Consultation Response from: KC Environmental Health (Pollution & Noise Control)

2023/90349 - adj, 11, Park View, Cleckheaton, BD19 3AN

Erection of detached dwelling**Date Responded:**
20th March 2023**Responding Officer:**
NH**Responding Ref:**
WK/202306494**Contaminated Land**

Site Plan 1:100

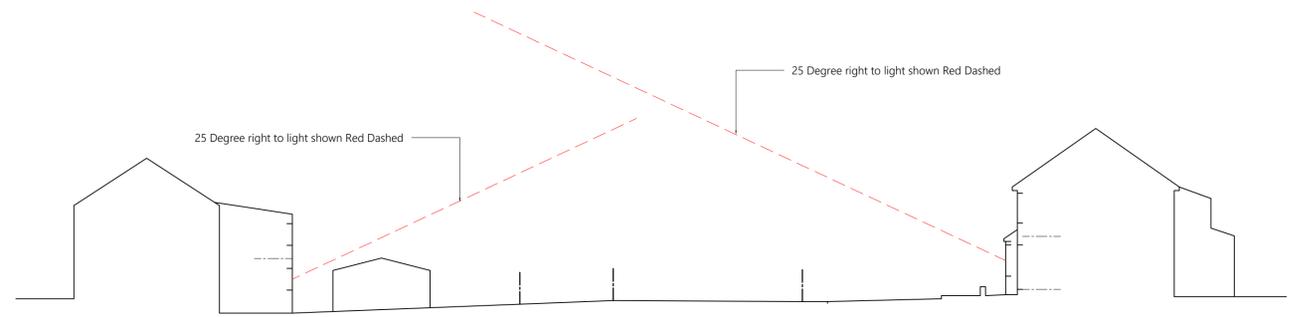
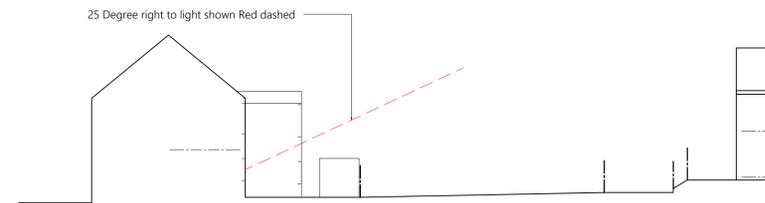
We understand there is to be 2 parking spaces at the proposed property. However, no electric vehicle charging point appears to have been proposed. In application of this nature, it is expected that facilities for charging electric vehicles and other ultra-low emission vehicles are provided in accordance with the National Planning Policy Framework and *Air Quality & Emissions Technical Planning Guidance* from the West Yorkshire Low Emissions Strategy Group.

Before first occupation, a scheme detailing the dedicated facilities that will be provided at the dwelling house for charging electric vehicles and other ultra-low emission vehicles shall be submitted to and approved in writing by the Local Planning Authority. The scheme shall meet the requirements of the current West Yorkshire Low Emission Strategy (WYLES) document. The approved dedicated facilities for charging electric vehicles shall be installed prior to occupation and retained for use thereafter. Before the dwelling house is occupied the EVCPs should be installed.
